## REQUEST

Current Zoning: R-3 (single family, residential)  
Proposed Zoning: R-17MF(CD) (multi-family residential)

Approximately 20.85 acres located along the south side of Ridge Road and north side of the Interstate 485 interchange.

The petition proposes a residential community of up to ~~213~~ 198 single family attached townhome style dwelling units.

**SCHEMATIC**  
**SITE PLAN**

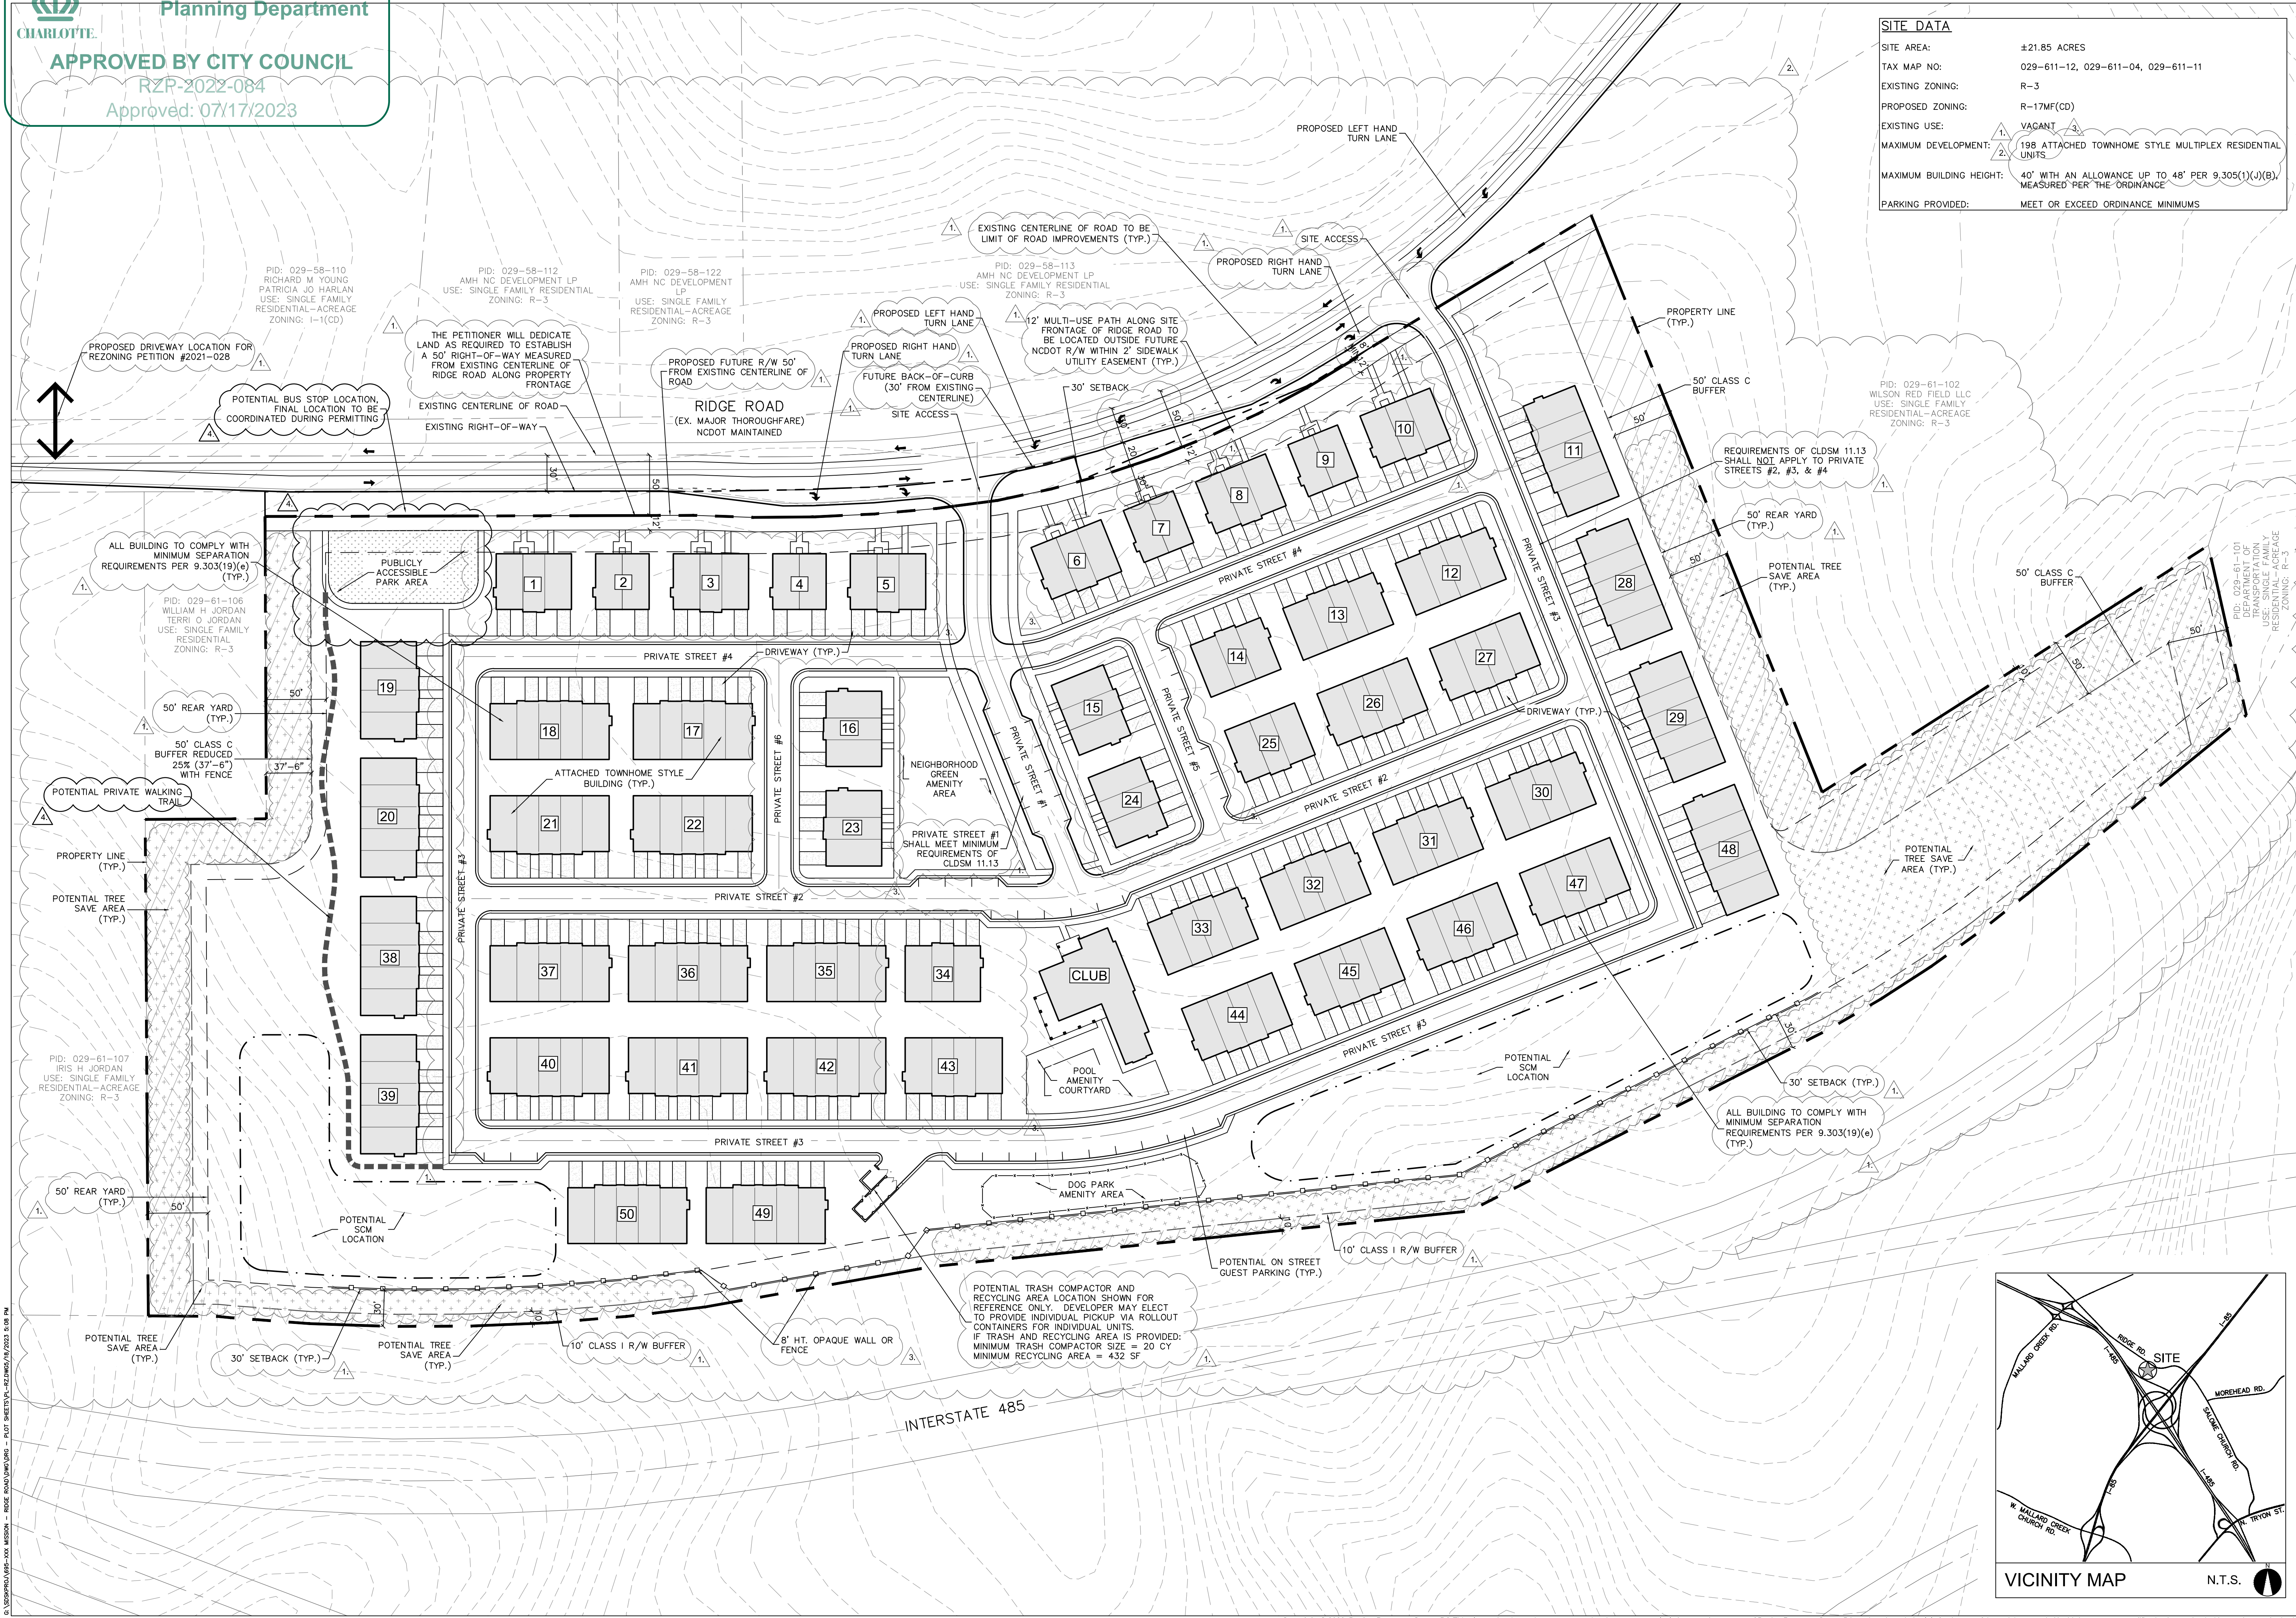
2. ~~Reduce unit count and number of buildings with a mix of single family, duplexes, and triplexes to be consistent with the Neighborhood 1 place type.~~ Addressed

- Allows up to ~~213~~ 198 single family attached townhome style dwelling units.
- Limits maximum building height to 48-feet.
- Commits to constructing turn lanes along the site's public street frontage.
